**RIX'S CREEK COAL MINE EXTENSION PROJECT (SSD 6300)  
RESPONSE TO SUBMISSIONS REPORT**

I refer to your email to the Environment Protection Authority (EPA) dated 31 October 2016, seeking comments on the Response to Submissions (RTS) report titled *"Rixs Creek Mine – Continuation of mining project Environmental Impact Statement Response to Submissions"*, prepared by AECOM and dated 20 October 2016, in relation to the Rix's Creek Coal Mine Extension Project, SSD 6300.

**ATTACHMENT A:****Environment Protection Authority's Air Quality Assessment Review RTS**

The time-series plots presented in **Figure 3** and **Figure 4** indicate that **Table 6** is not an optimal indicator of potential impact. The plots show a general decline in overall impacts over time.

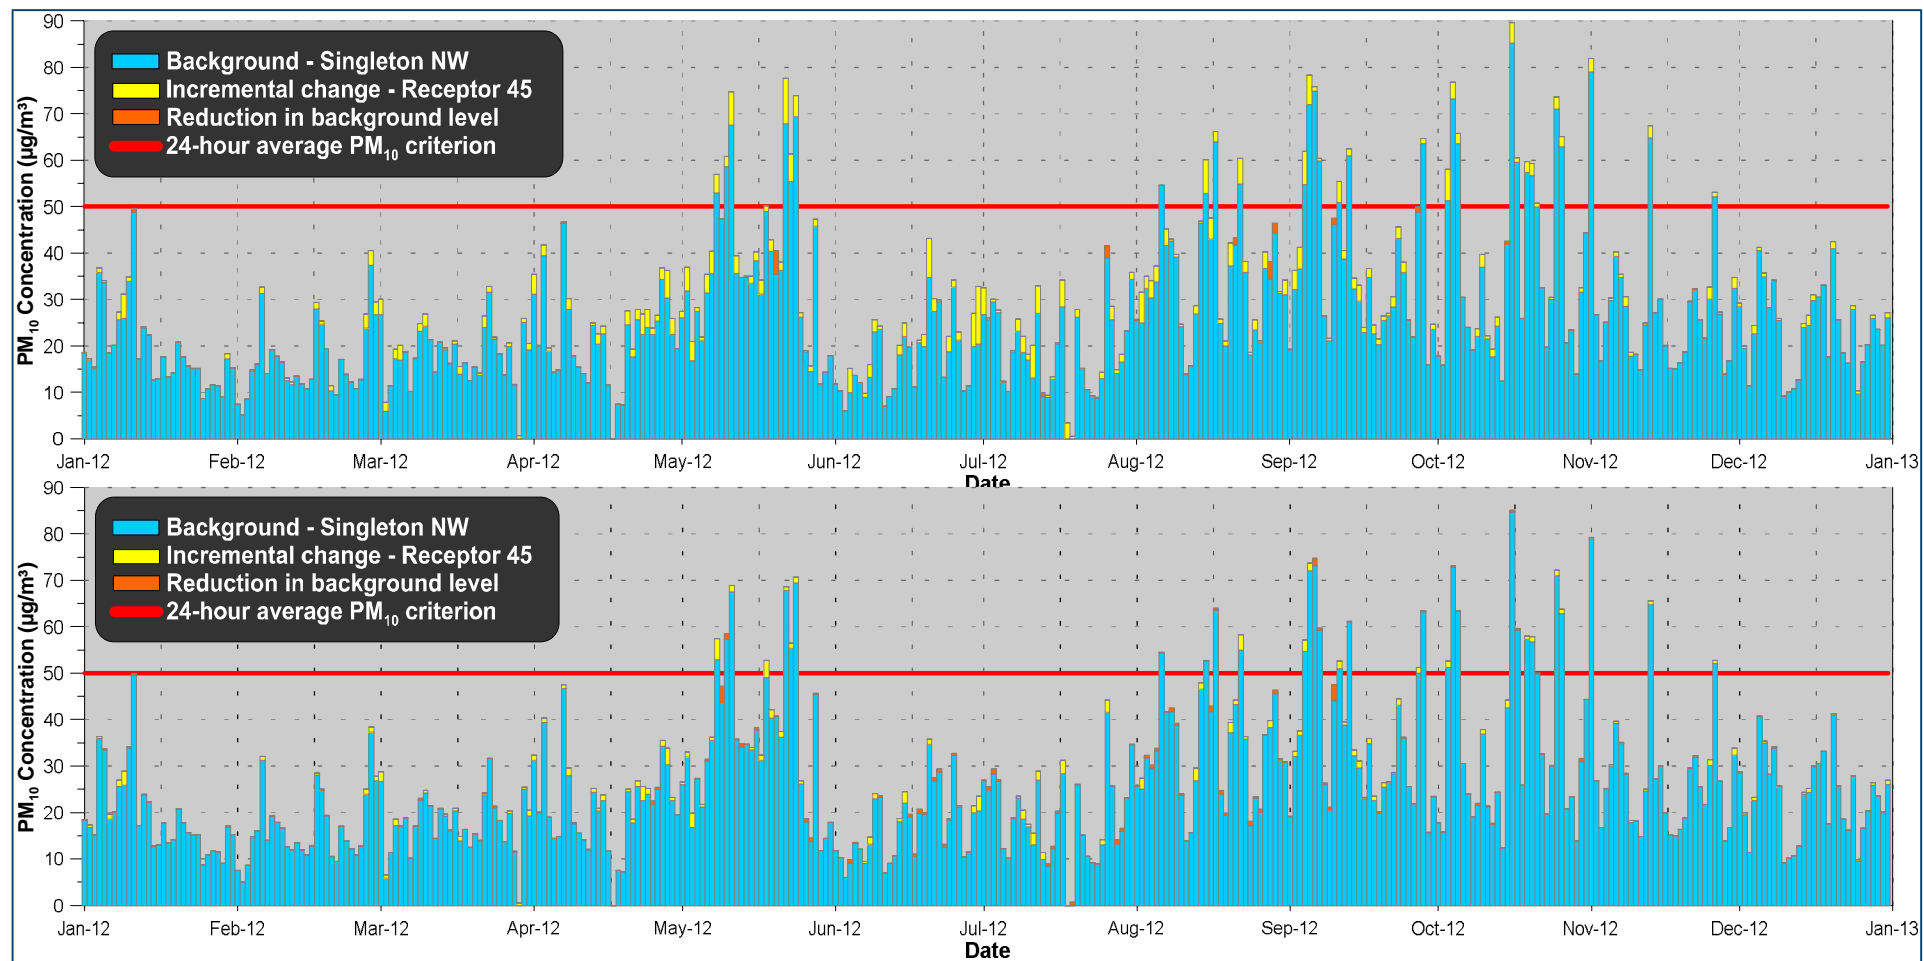
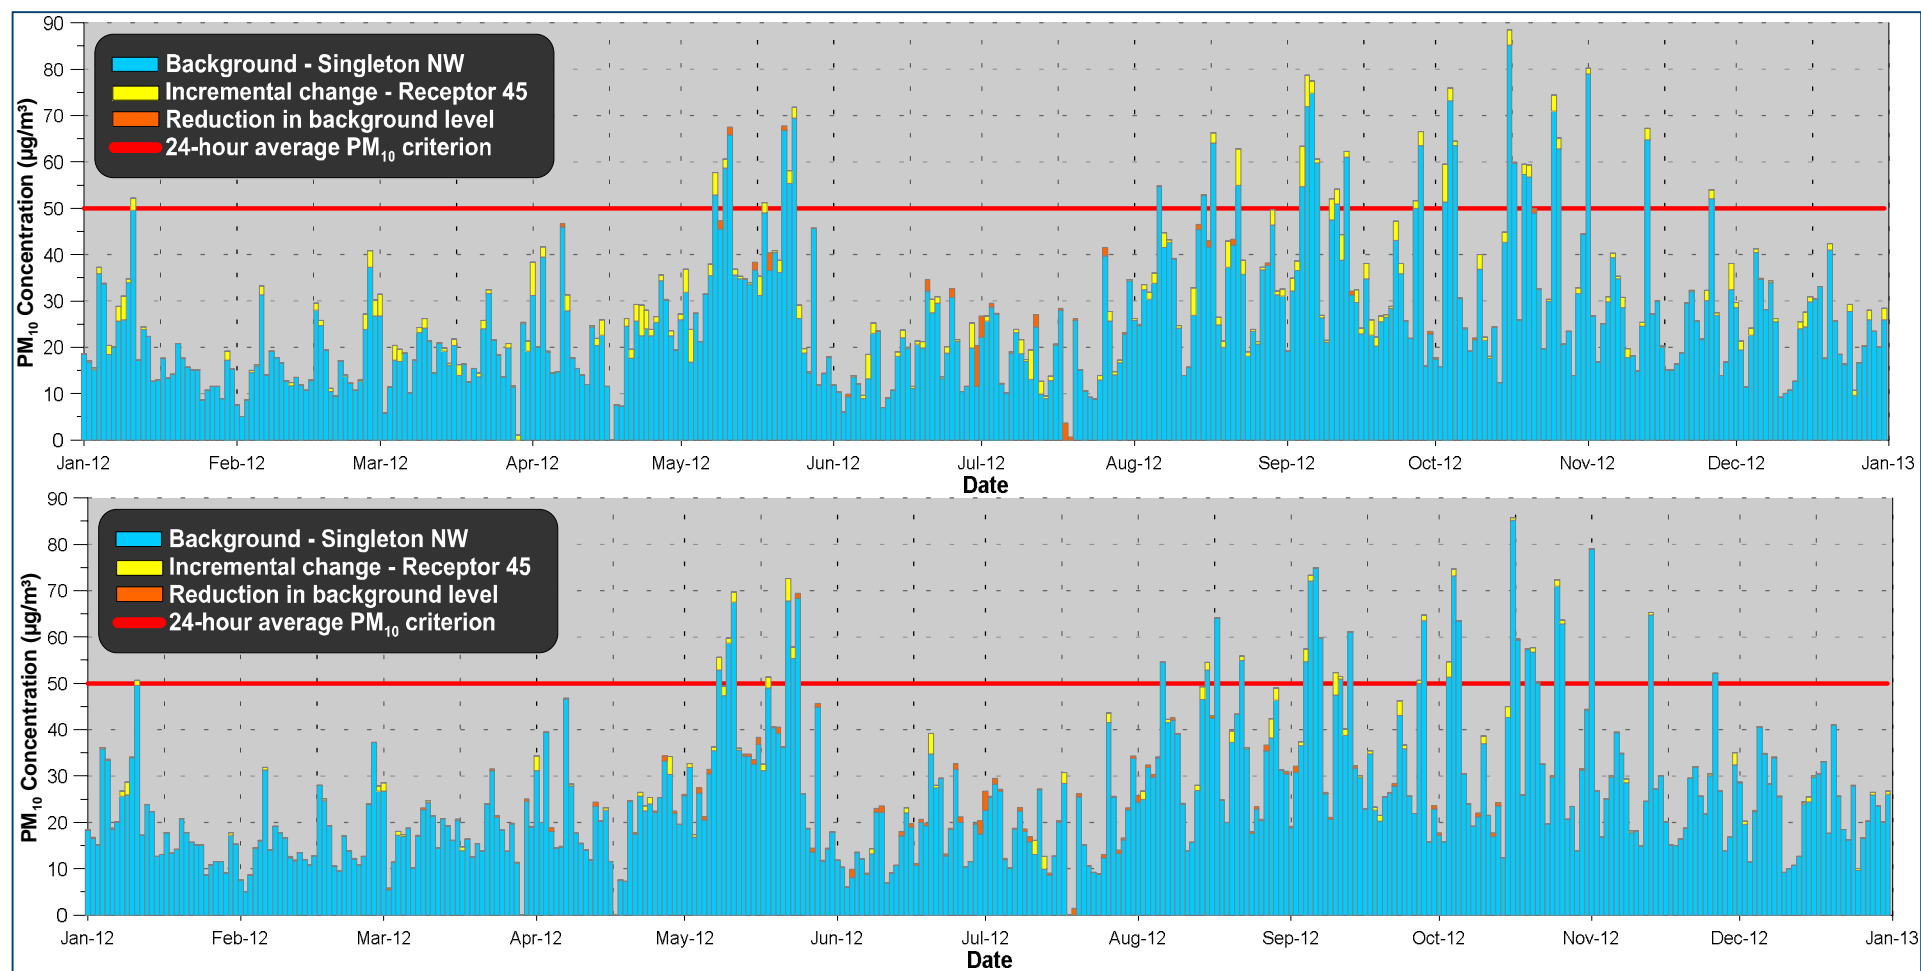
Similarly, the RTS provides a cumulative assessment for receptor 45 (table 6) which shows additional days exceeding the 24-hour PM<sub>10</sub> cumulative impact assessment criterion. Receptor 45 is in McDougalls Hill where at least eight other receptors are closer to the mine. It is likely that these eight receptors will also experience impacts greater than the EPA's impact assessment criteria. It is possible that other receptors in McDougalls Hill and Gowrie will experience impacts greater than the EPA's 24-hour PM<sub>10</sub> cumulative impact assessment criteria.

The EPA believe that cumulative assessment documentation is incomplete. Not all the receptors assessed as experiencing additional days exceeding the 24-hour PM<sub>10</sub> cumulative impact assessment criterion are identified in the assessment documents.
